WELWYN HATFIELD BOROUGH COUNCIL – DEVELOPMENT MANAGEMENT
DELEGATED REPORT

APPLICATION Nos: N6/2014/1988/FP & N6/2014/1862/AD

SITE ADDRESS: 31 Stonehill, Welwyn Garden City

DESCRIPTION OF DEVELOPMENT:

DRAWING TITLE: ELEVATIONS - PRO VS. EXT
DRAWING NUMBER: SV-WEI/WH-1.3 DWG
SCALE: AS SHOWN
PROJECT: 31 Stonehills, Wilwyn Garden City, AL8 6JA

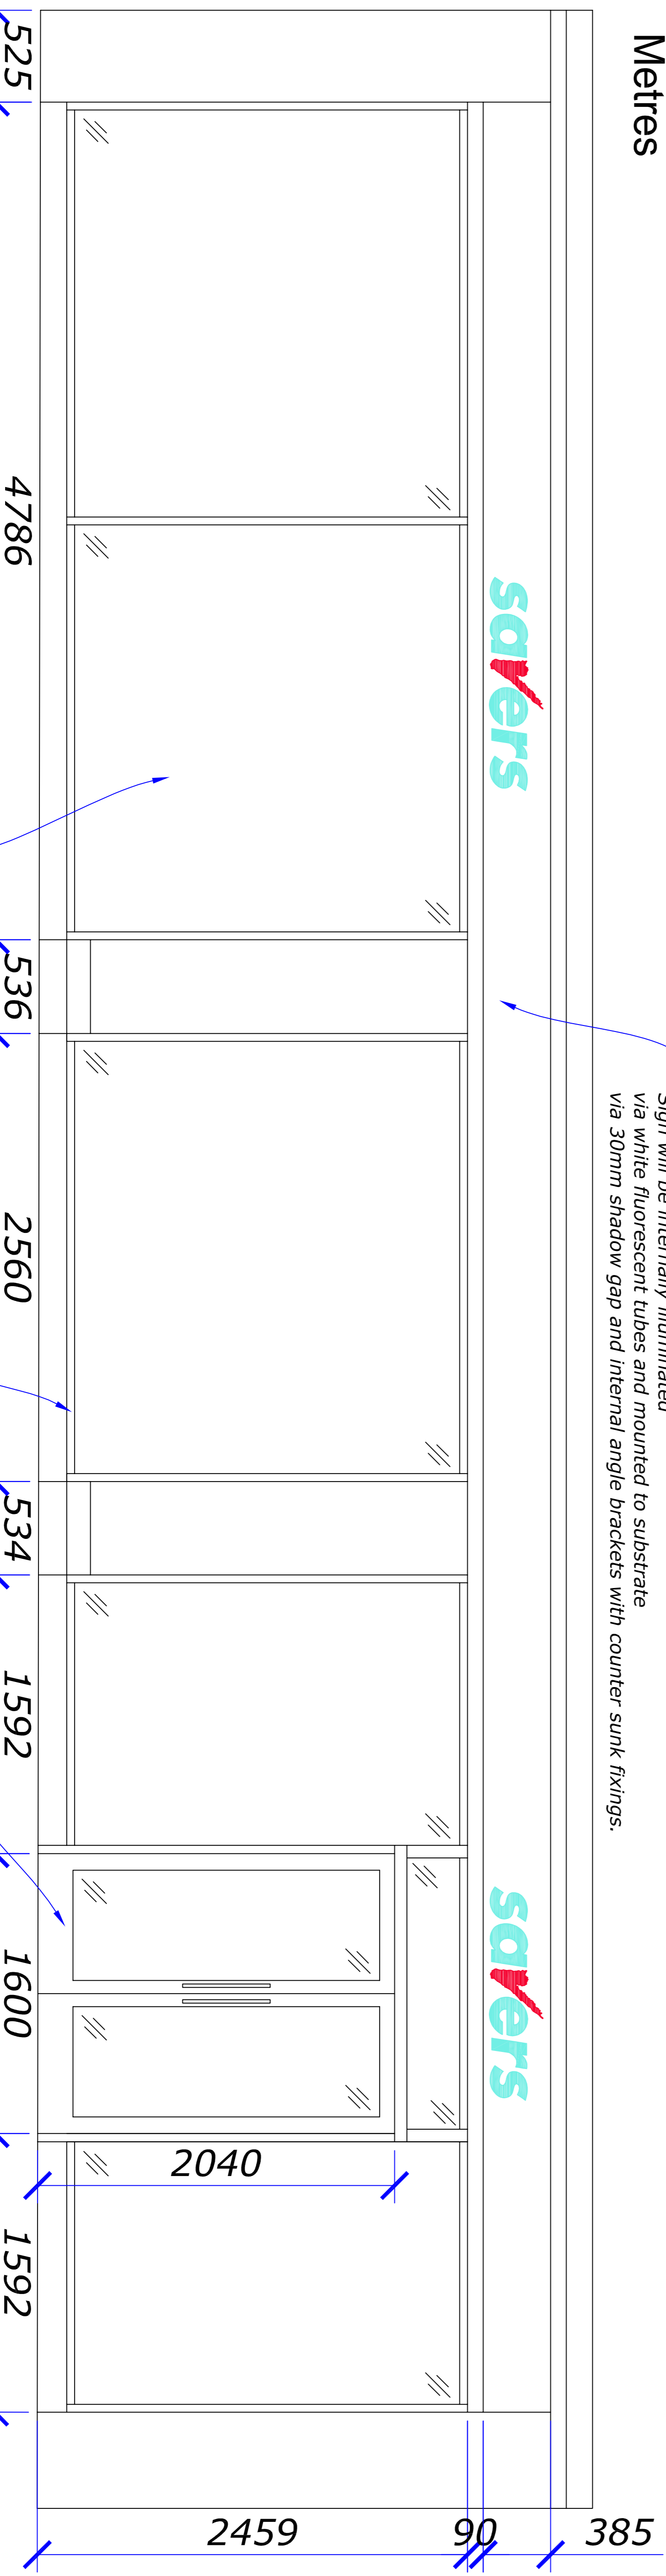
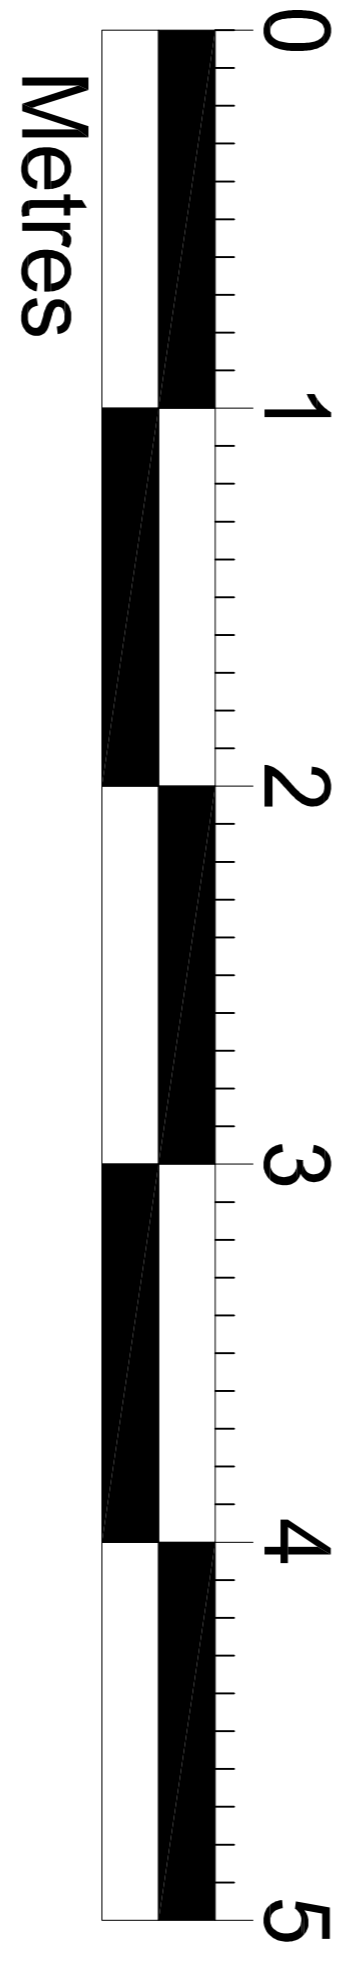
N6/2014/1988/FP: The proposed replacement shopfront was considered to be unacceptable in that it would result in an off-set shop entrance onto the street and the loss of the centrally located recessed door and symmetrical shape to the shopfront with the full-height, double windows either side of the door being lost. Following the receipt of the amended plans on 19/9/14, it is noted that the existing shopfront is to be retained.

It is considered that the retention of the shopfront, and its repainting in white is acceptable in that it would maintain the existing shopfront design which sustain the character and appearance of the Welwyn Garden City Conservation Area in accordance with advice contained in the NPPF; District Plan Policies D1 and D2; and, the adopted SPD, Welwyn Garden City – Guide to Shopfront and Advertisement Design (September, 2012).

N6/2014/1862/AD: It is considered that the changes indicated in the submission of amended Drawing No. SV-WELWYN-LC3-DWG Revision L3C#3 – comprising a centrally located ‘Savers’ fascia sign above the retained central front door comprising

of individual letters located and in proportion to the fascia and the non-illuminated projecting sign on the R/H side of the shop front are acceptable. Herts CC –

Highways has raised no objections on highway safety grounds subject to the control of the light output which can be achieved via the imposition of the LHA's suggested condition. The proposed fascia sign would be lit via a trough light above which would be fixed to the cornice. This would be static and would be at 800cd/ms which complies with the advice from the Institution of Lighting Engineers.

8. The intensity of the illumination of the trough light hereby permitted by this consent shall be no greater than 800 cd/m unless otherwise agreed in writing by the Local Planning Authority.
